# PARTIAL FIRST FLOOR PLAN

<b>DRAWN:</b> PSE	<b>CHECKED:</b> PSE	<b>DATE:</b> 02/27/20	<b>PROJECT #:</b> 1901-010152
----------------------	------------------------	--------------------------	----------------------------------

<b>CLIENT:</b> CHRIS MUNZ	<b>PROJECT:</b> MUNZ RESIDENCE	<b>DRAWING NUMBER:</b> 1 of 3	<b>SHEET:</b> S2
---------------------------	--------------------------------	-------------------------------	------------------

<b>CLIENT:</b> CHRIS MUNZ	<b>PROJECT:</b> MUNZ RESIDENCE	<b>DRAWING NUMBER:</b> 1 of 3	<b>SHEET:</b> S2
---------------------------	--------------------------------	----------------------------------	---------------------

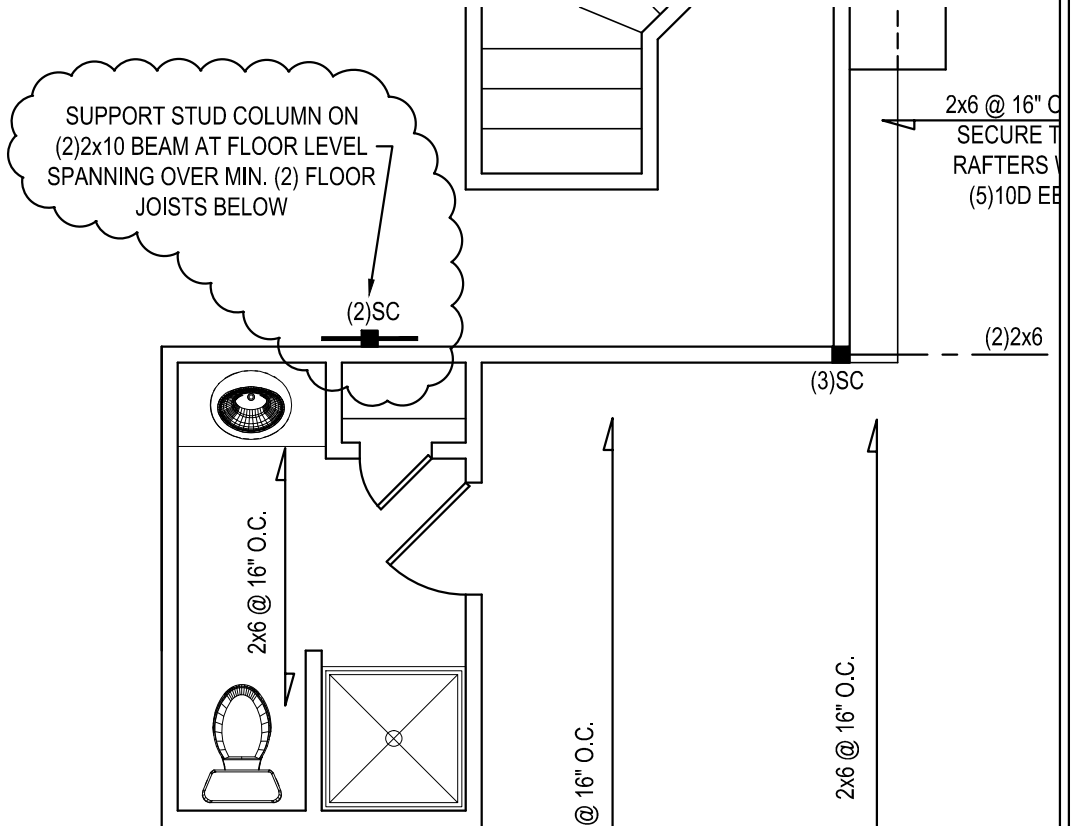
- 1) SUPPORTS ADDED FOR NEW POINT LOADS FROM DOUBLE RAFTERS

<b>CLIENT:</b> CHRIS MUNZ	<b>PROJECT:</b> MUNZ RESIDENCE	<b>DRAWING NUMBER:</b> 2 of 3	<b>SHEET:</b> S3
---------------------------	--------------------------------	-------------------------------	------------------

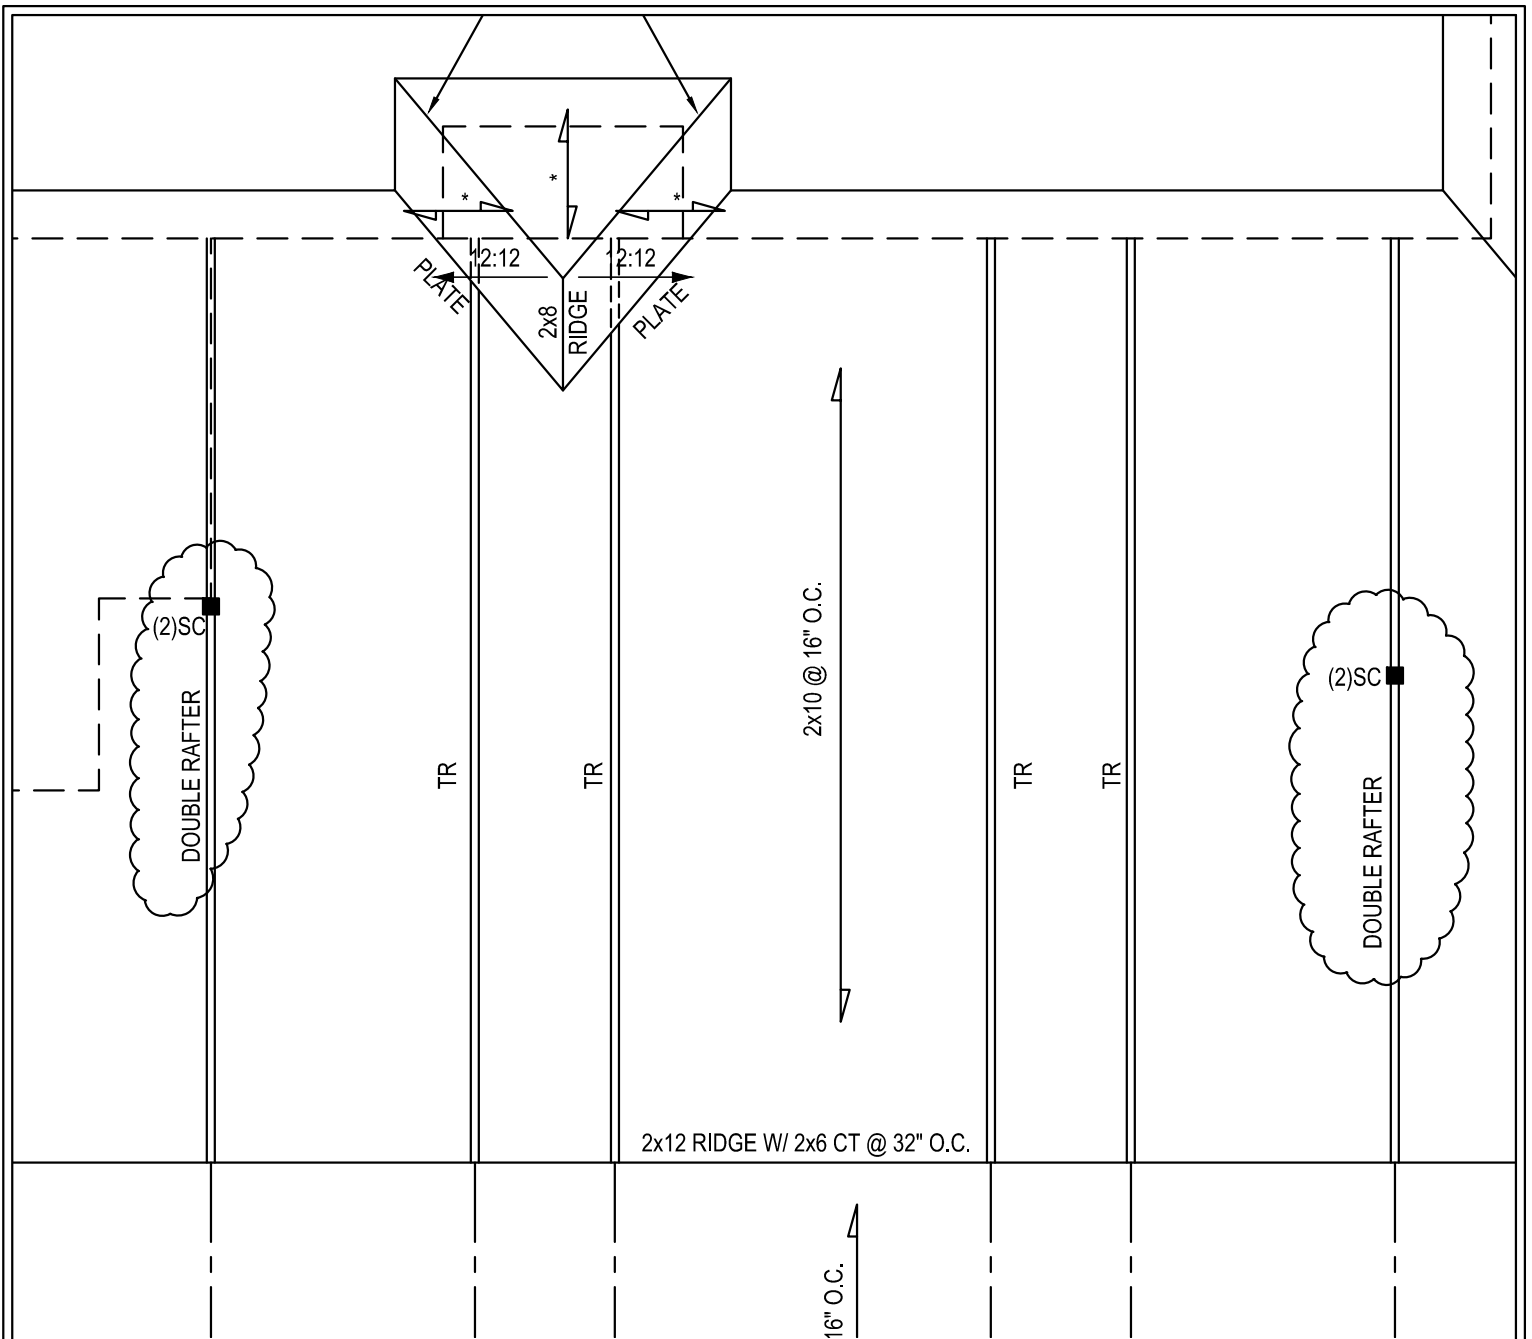
1) STUD COLUMN ADDED FOR SUPPORT OF DOUBLE RAFTER.

Sheet Number
S4
 of 9

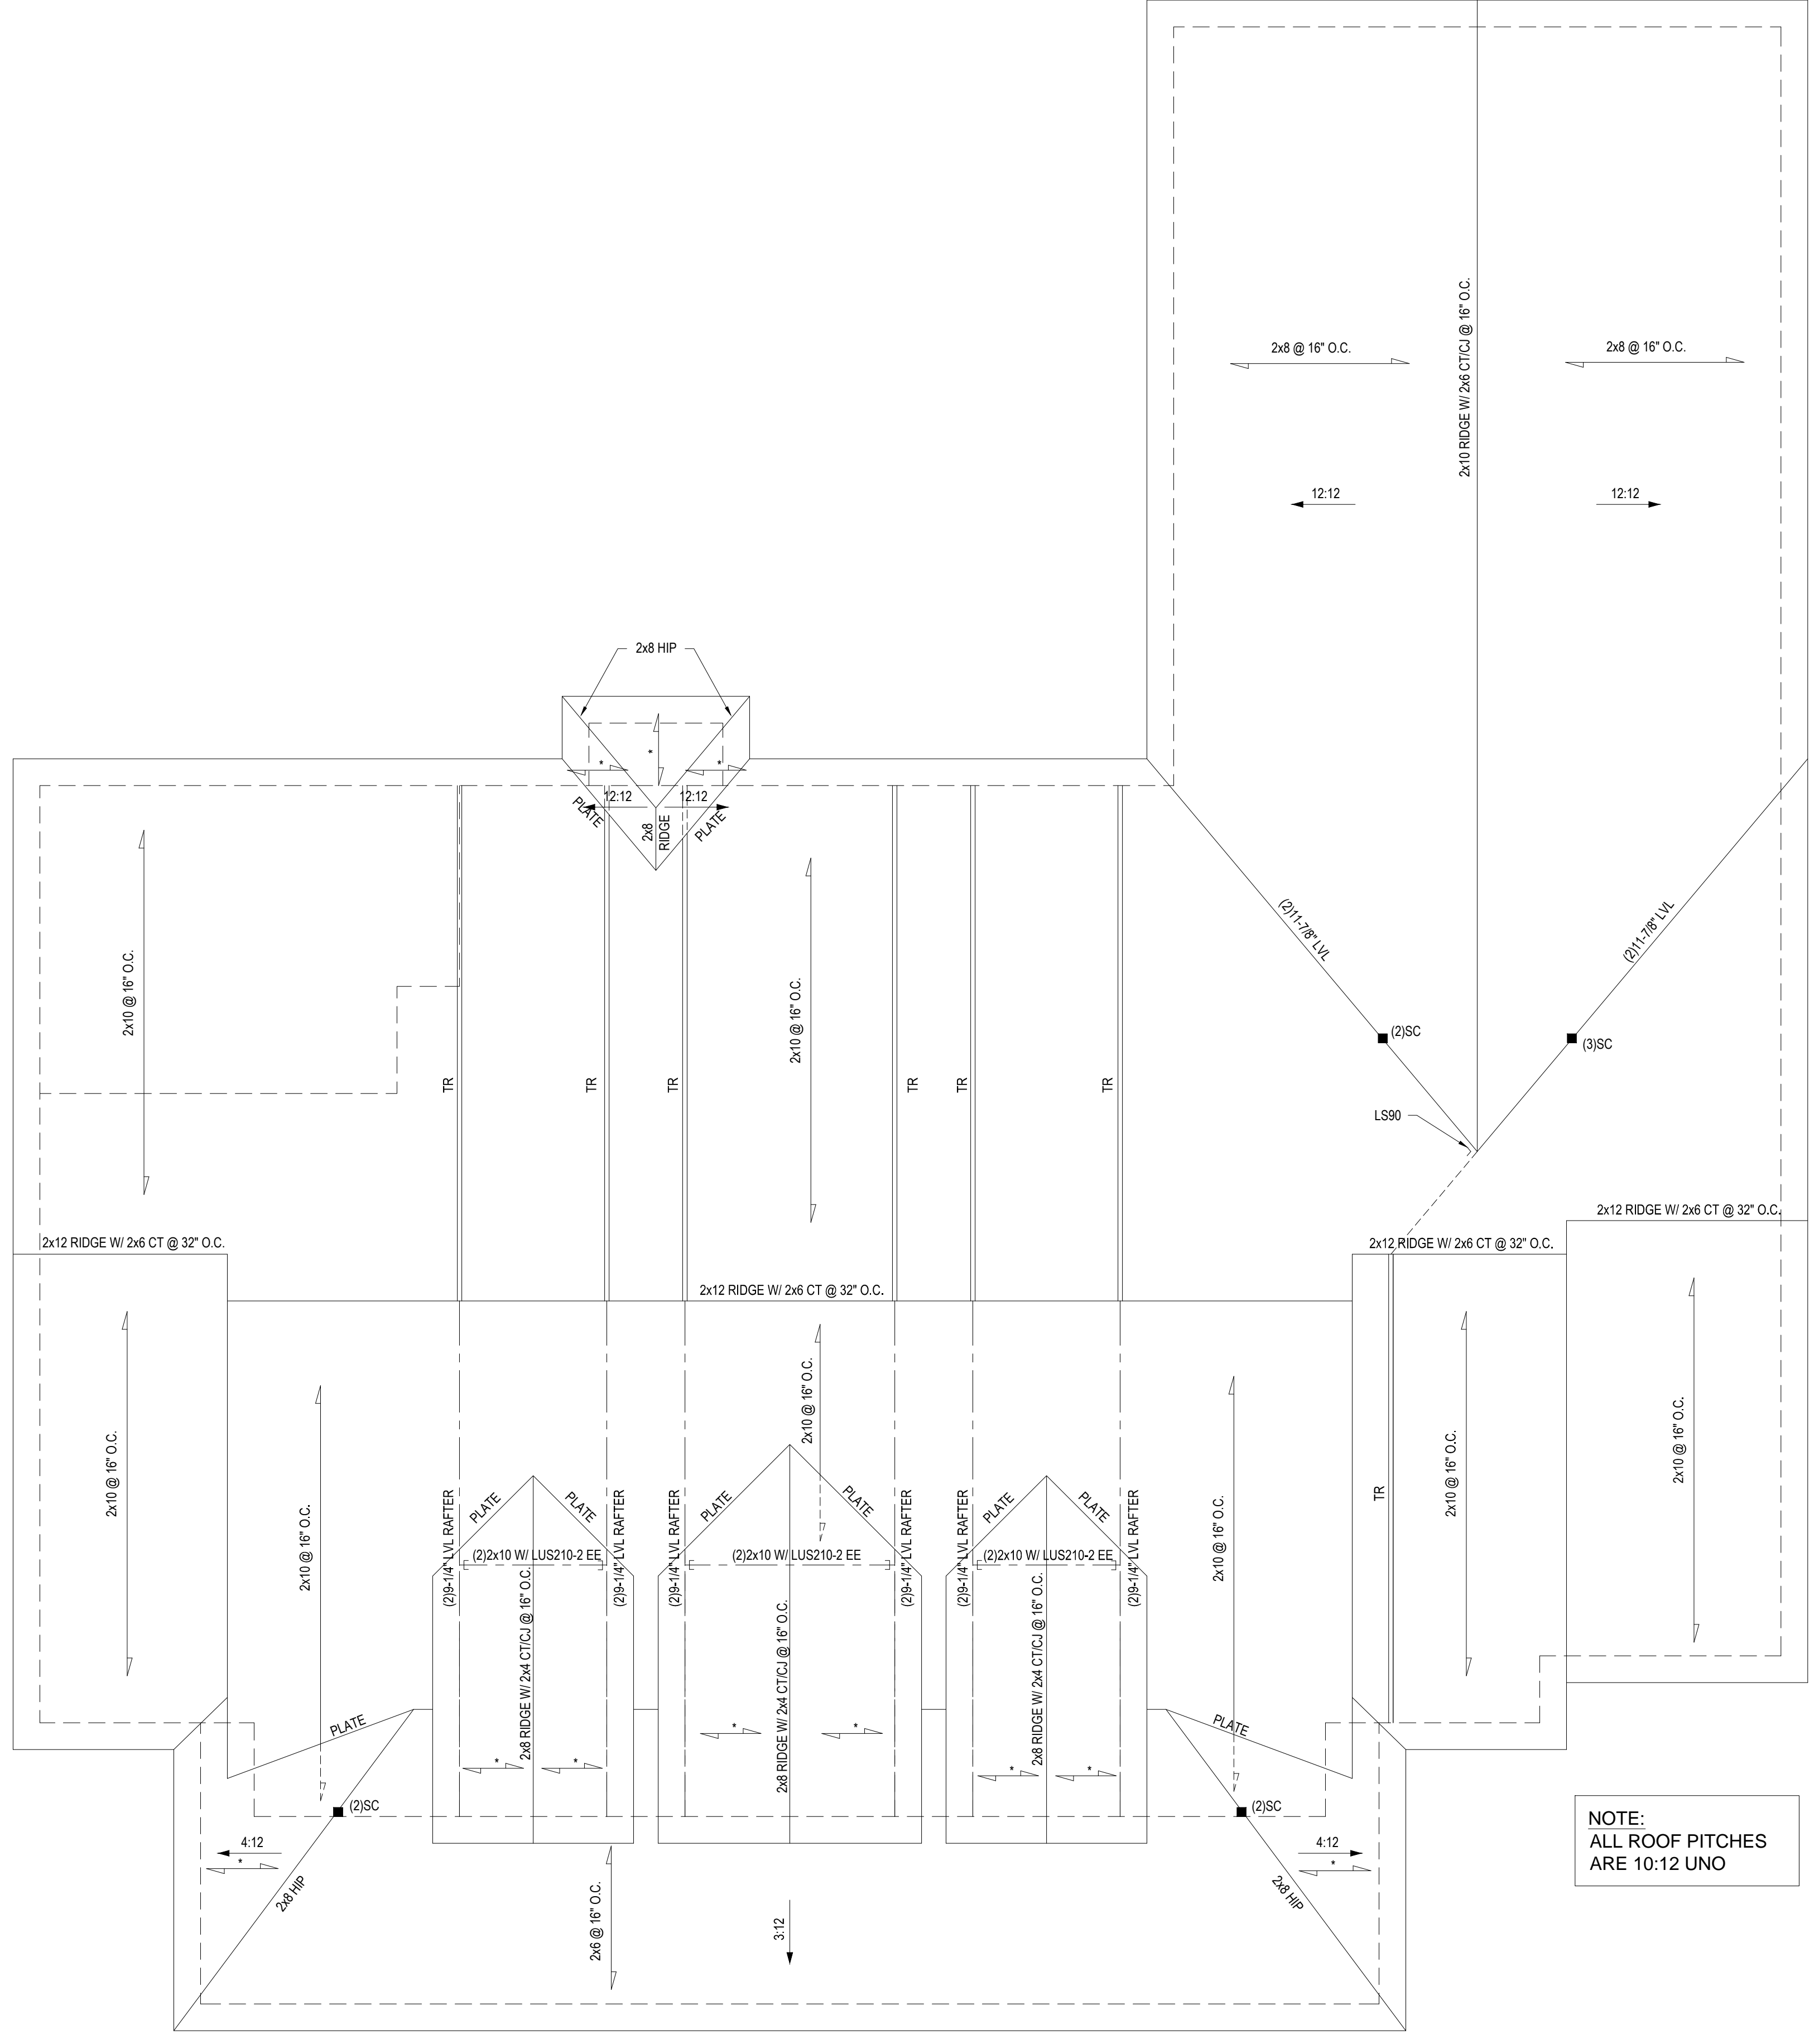
- 1) SUPPORTS ADDED TO REDUCE PLAN SPECIFIED TRIPLE RAFTER TO DOUBLE RAFTER.
